Fire Marshal Division

**Re: Harnett County DSS Addition
200 Alexander Drive
Lillington, NC 27546**

Re: Application Number – FMFW2002-0008

Fire Alarm System Plan Review Notes:

FIRE ALARM SYSTEM
DEVICE PLACEMENT PLAN

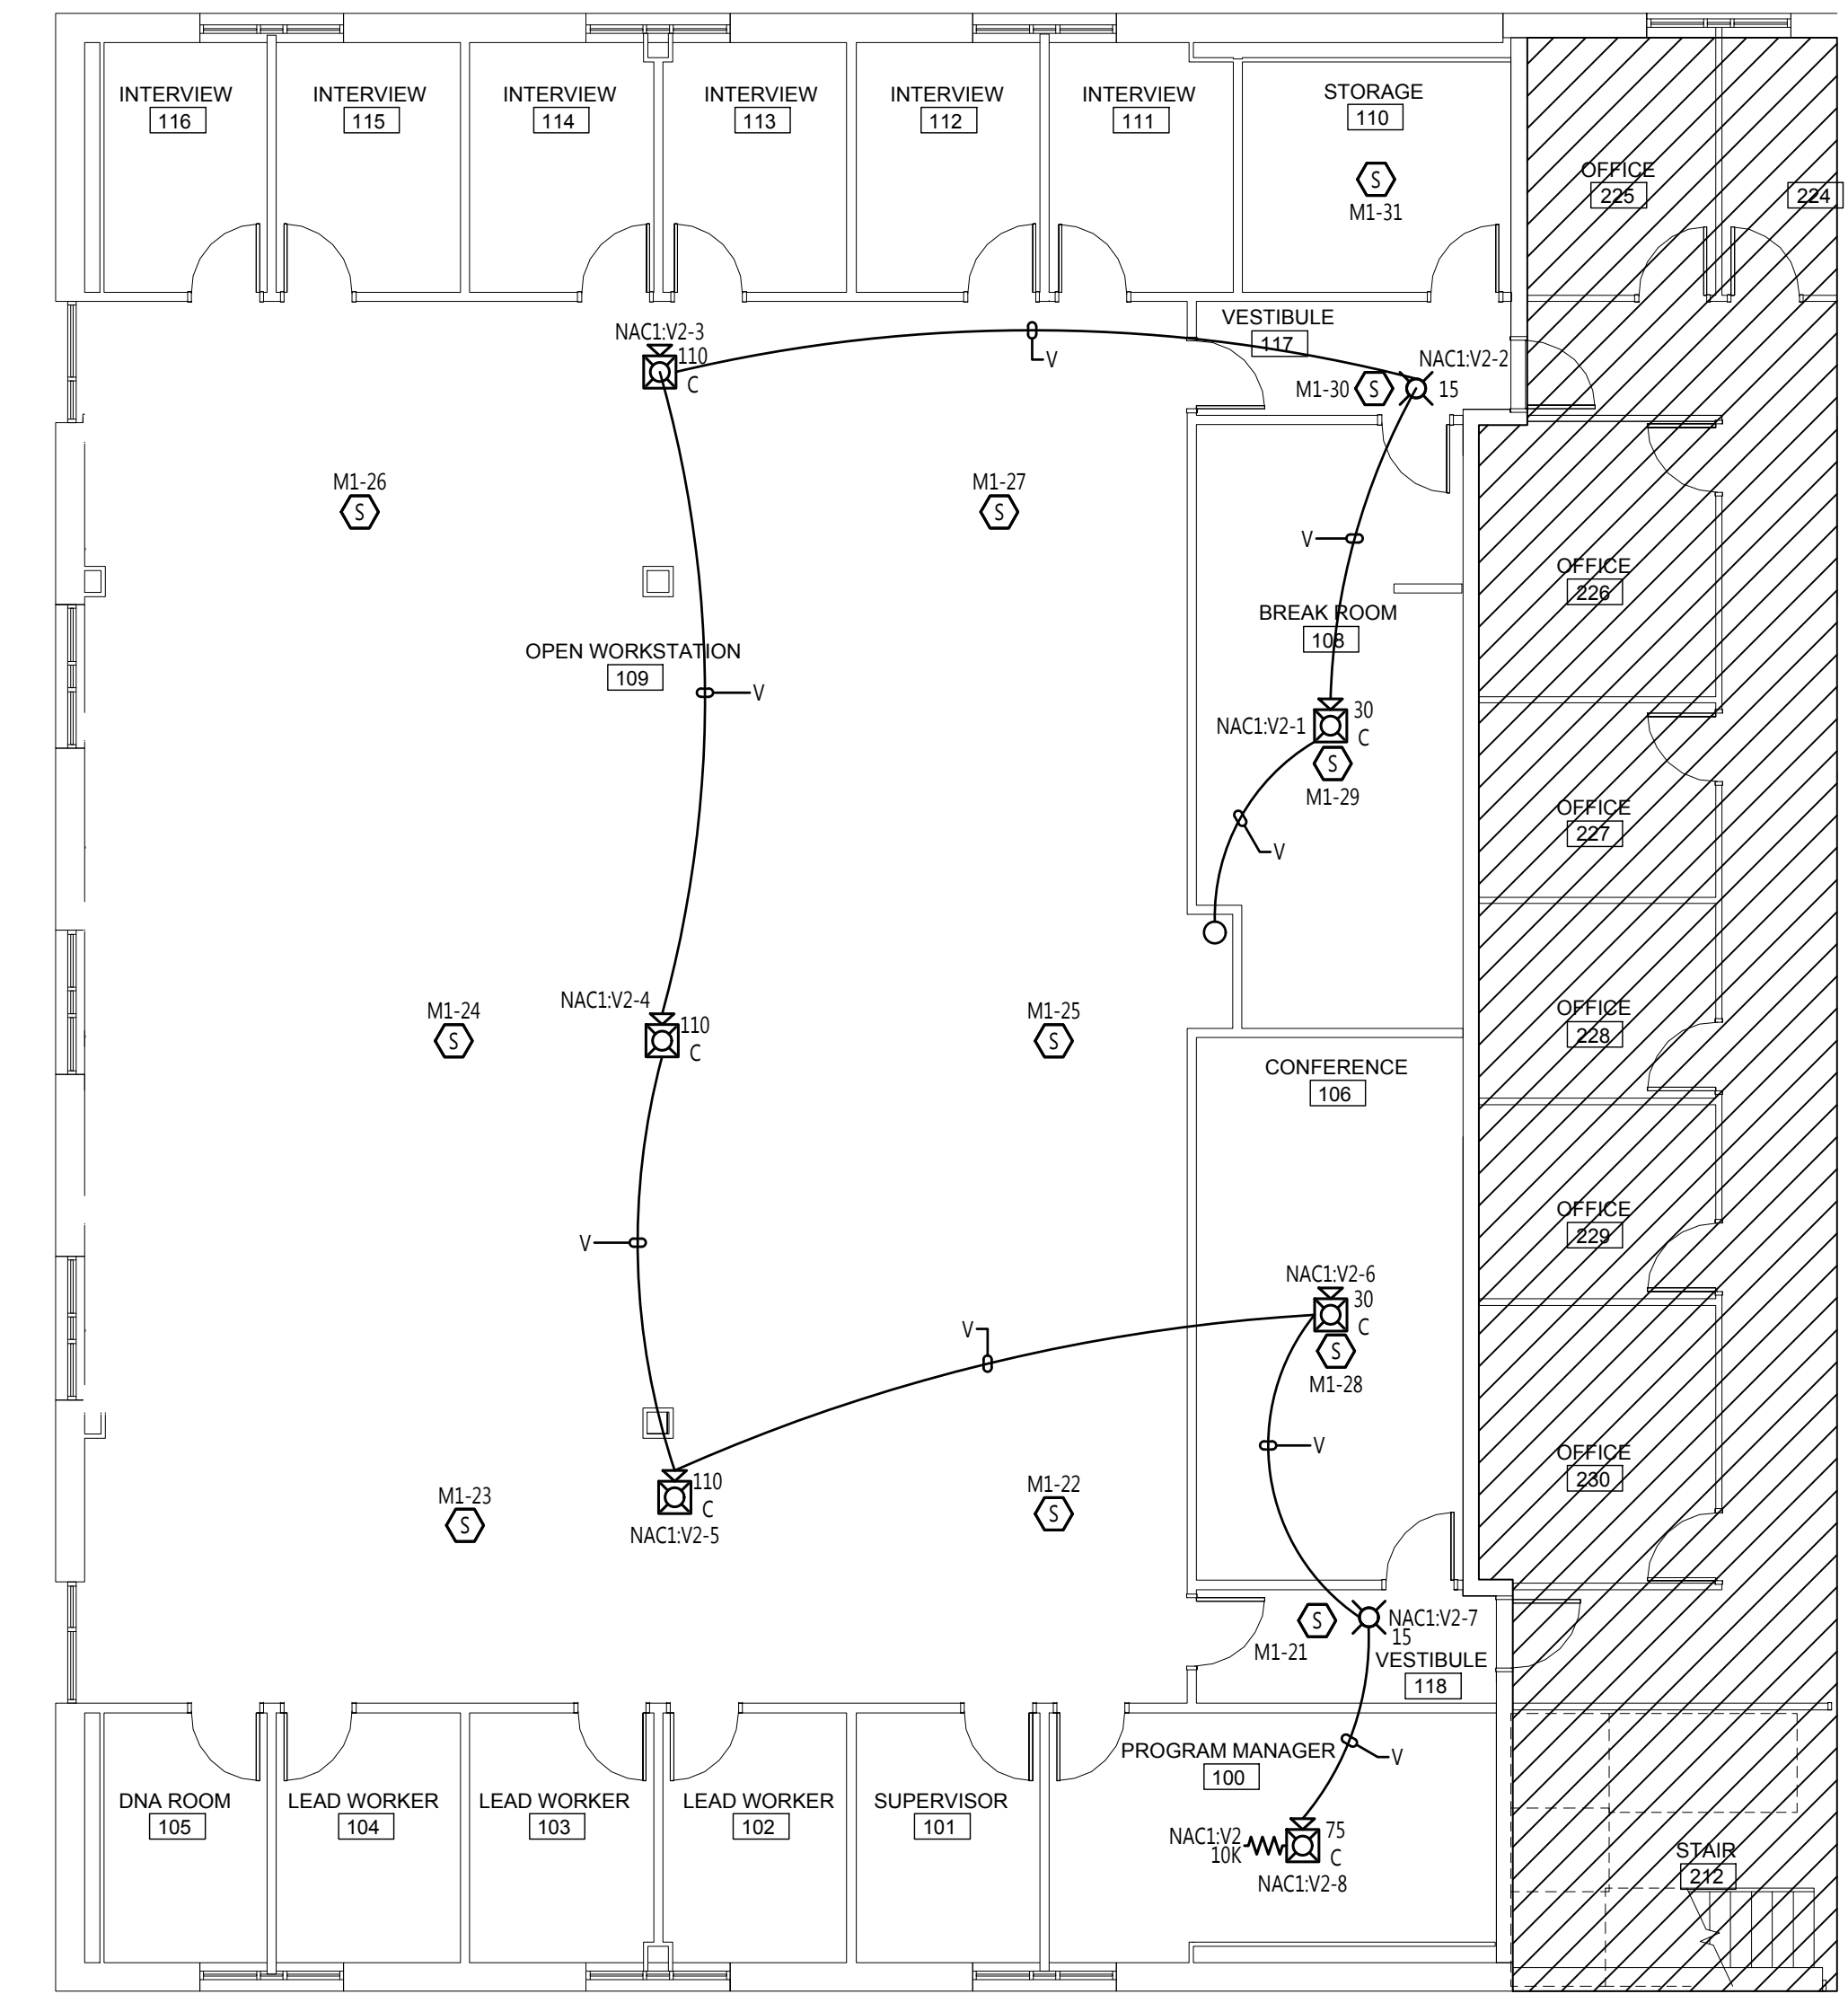
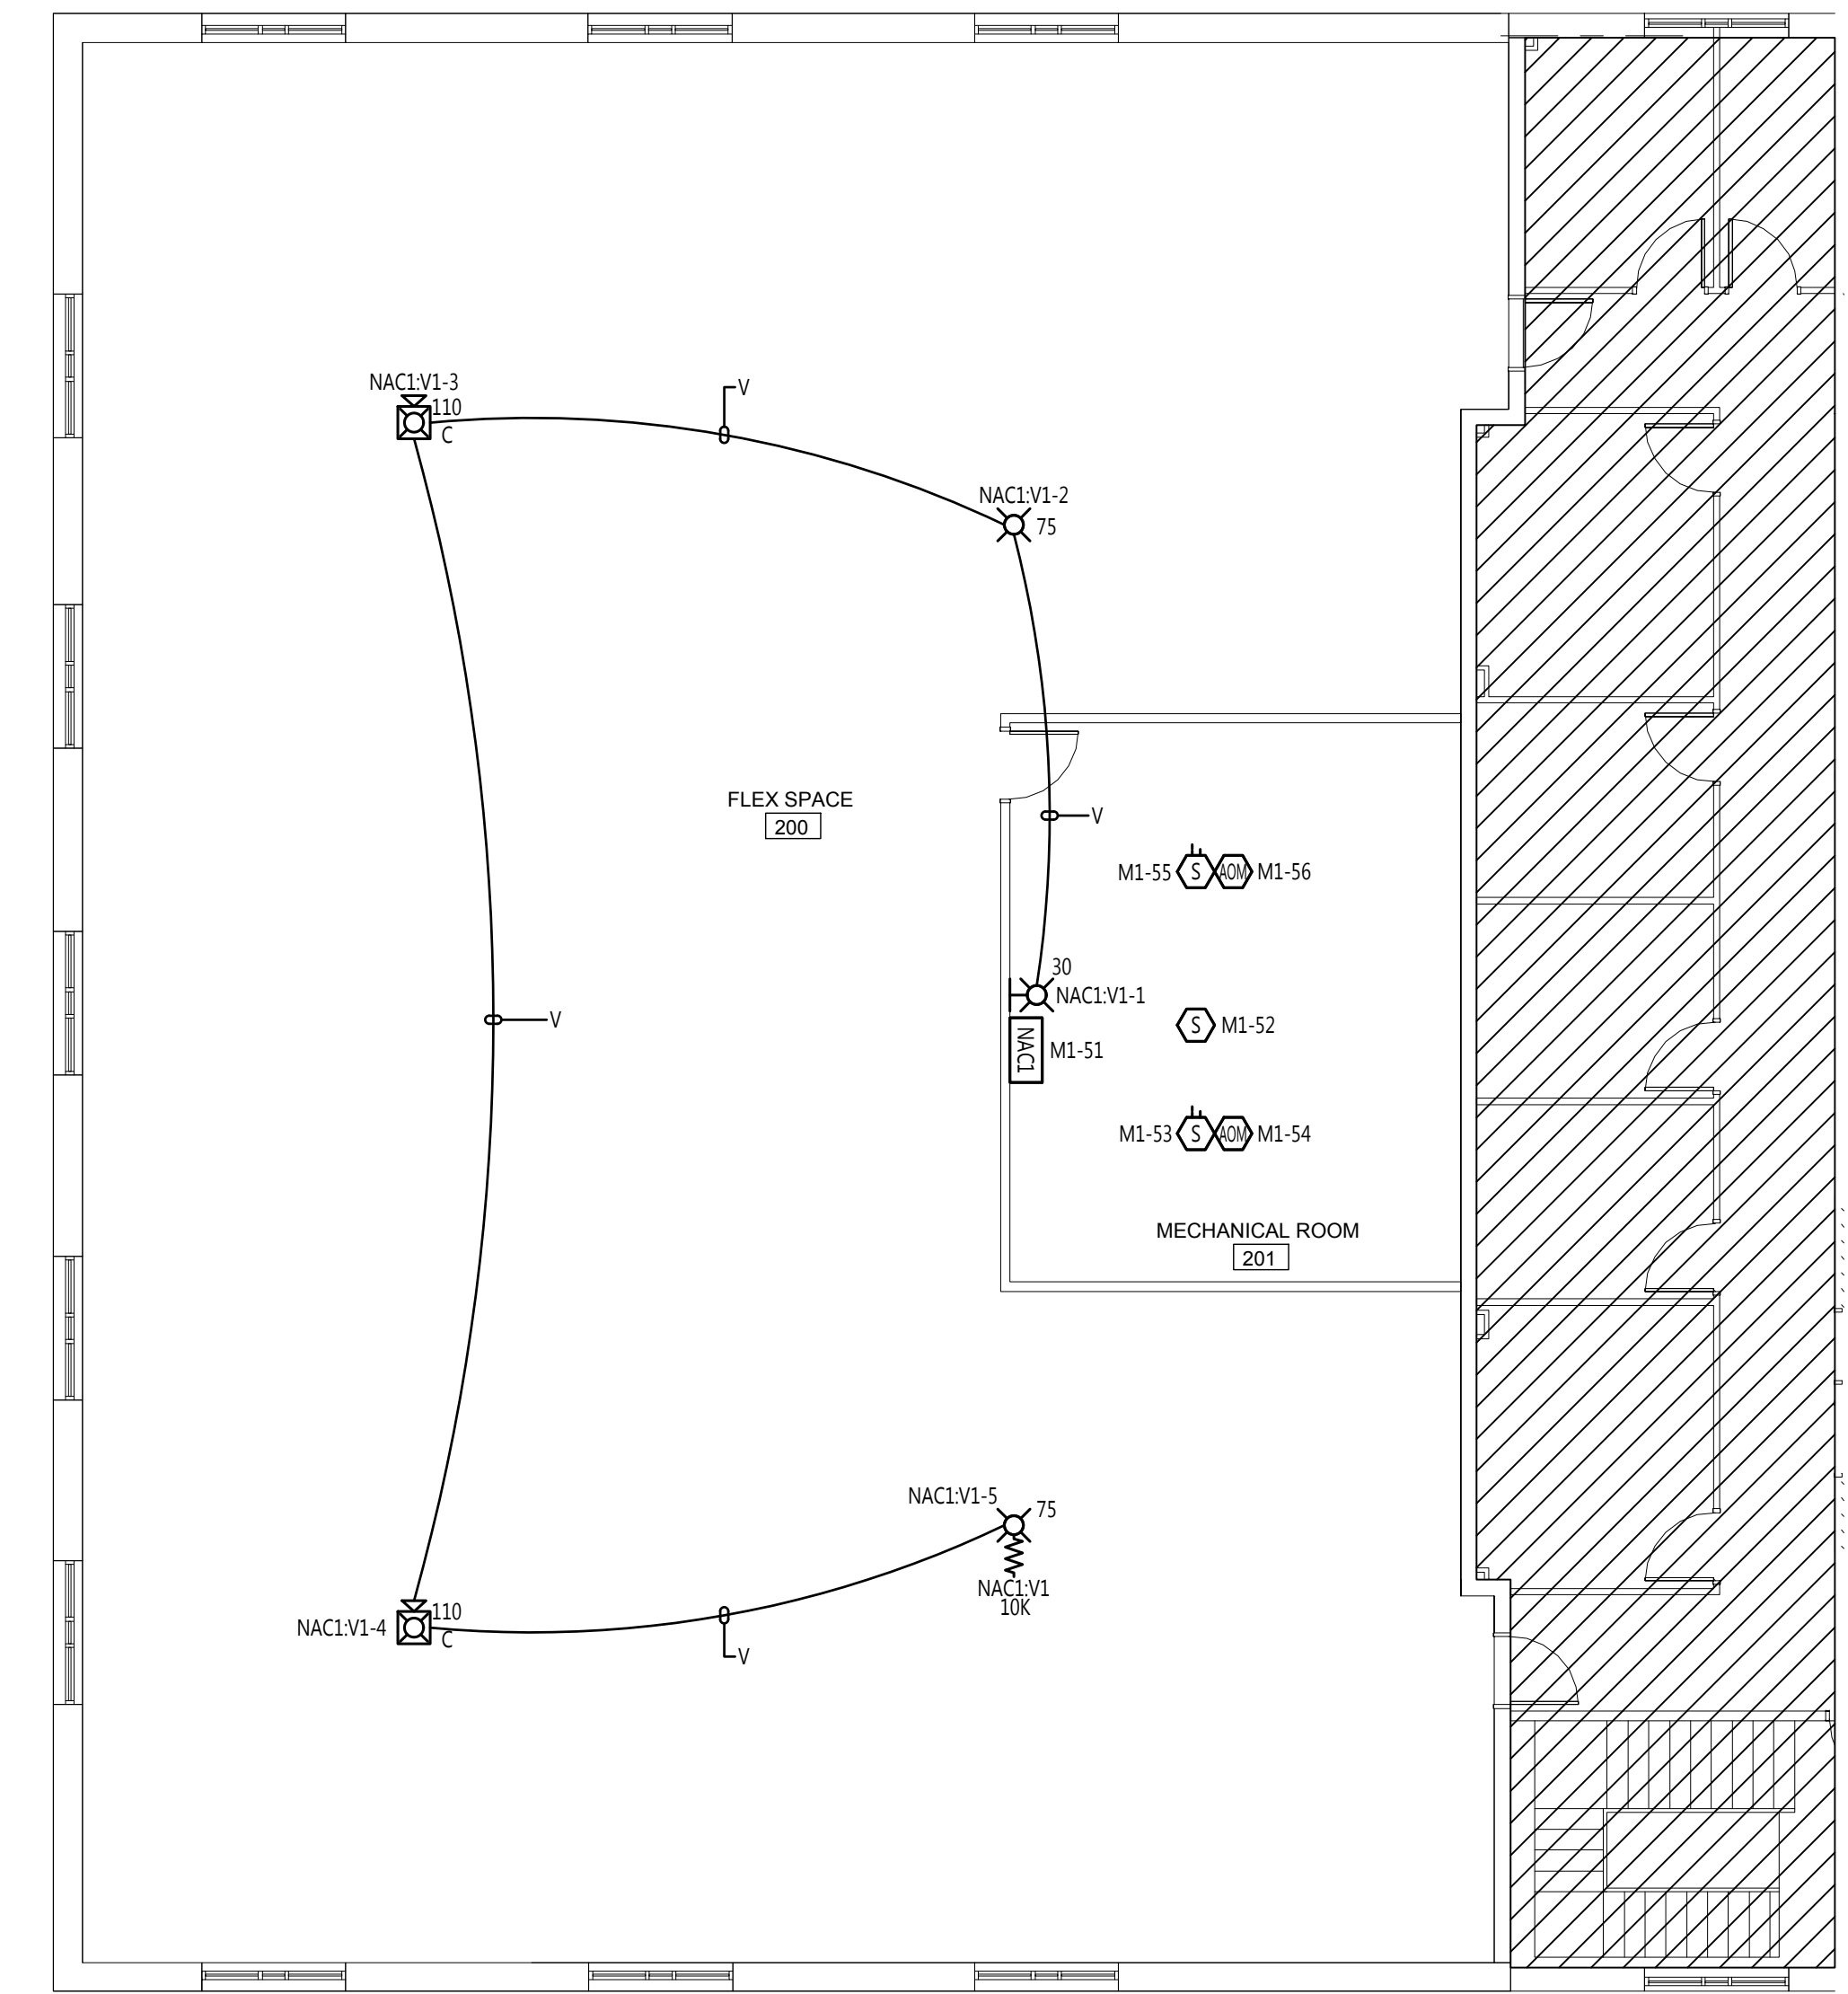
- **Public and common areas**
 - Visible alarm notification appliances shall be provided in public areas and common areas.
 - Notification devices required in meeting room and conference room.
 - Sound pressures shall comply with 907.6.2.1.1 – 907.6.2.1.2 of the NCFPC, current edition.

- Provide coverage for the second floor flex space as covered on the first floor to provide early notification since the space will not be initially occupied.
- Provide a record of completion.
